WCC PAPER No. 6

Winchester City Councils Comments on the Denmead Meadows Position Paper (REP6-072)

Figure 1 – 2019 NVC survey results, field numbering and HDD5 reception compound.

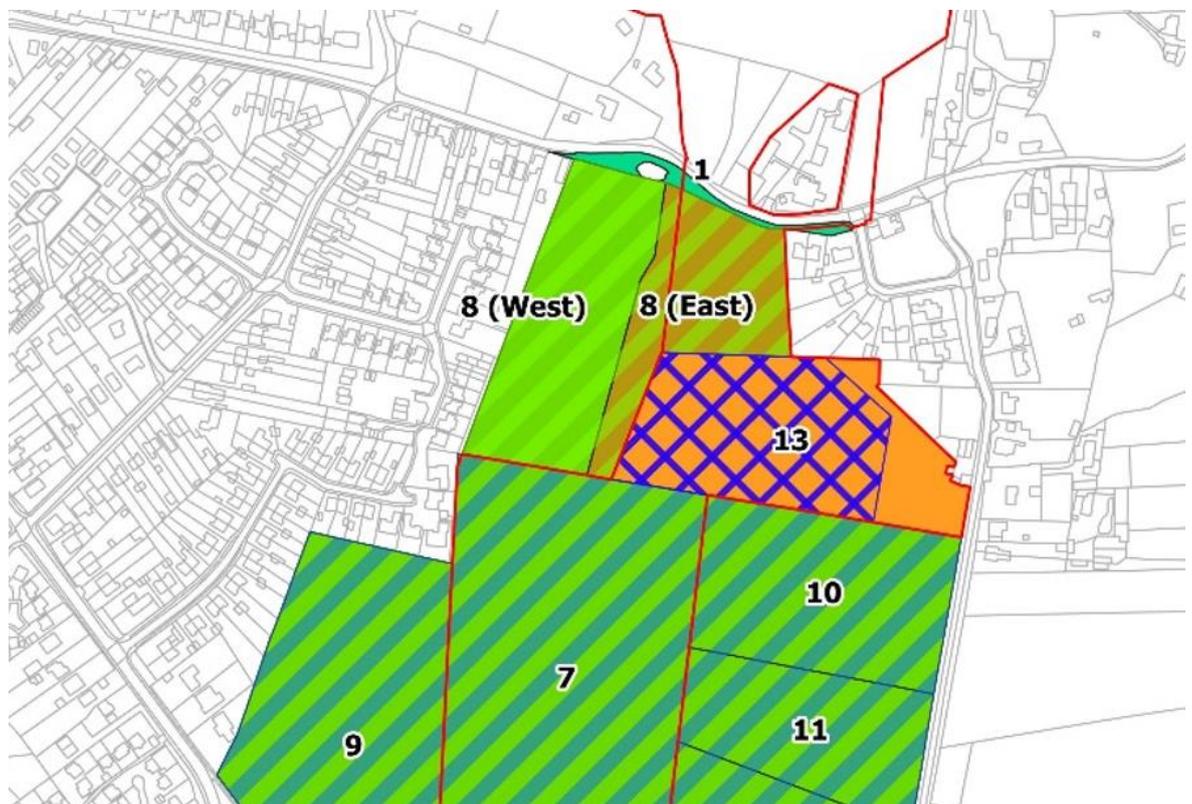
The Council would like to take the opportunity of submitting a report on the habitat quality of the Kings Pond SINC entitled Hampshire Biodiversity Information Centre Kings Pond Meadow Habitat Survey May 2020. The Council is not the author of this report and has only recently obtained the agreement of the authors for its release. This report is considered to support the Councils position that the habitat value of the Kings Pond Meadow SINC and specifically Field 8 east should have a greater level of regard applied to it than the applicant has applied.

The technical reasons why the drilling section cannot be extended northward to emerge on the agricultural land north of Anmore Road have already been outlined and accepted. This leads to the conclusion that the compound has to be located south of the Anmore Road. Accordingly, the Council feels that the focus should be on minimising any impacts from its temporary presence. The applicants intentions are to remove a layer of soil and then reinstate this using any surplus seed from the

seed harvest undertaken as part of the restoration of the land at the southern end. Leaving the soil in situ and using protective mats and teram should be considered together with seeding. When constructing the open trenches careful removal of the seed bearing layer of soil with the use a micro digger or light pressure equipment with access limited to the smallest area necessary should be considered. The Council is ready to discuss with the applicant the methodology to be adopted to undertake the work and in the reinstate the ground.
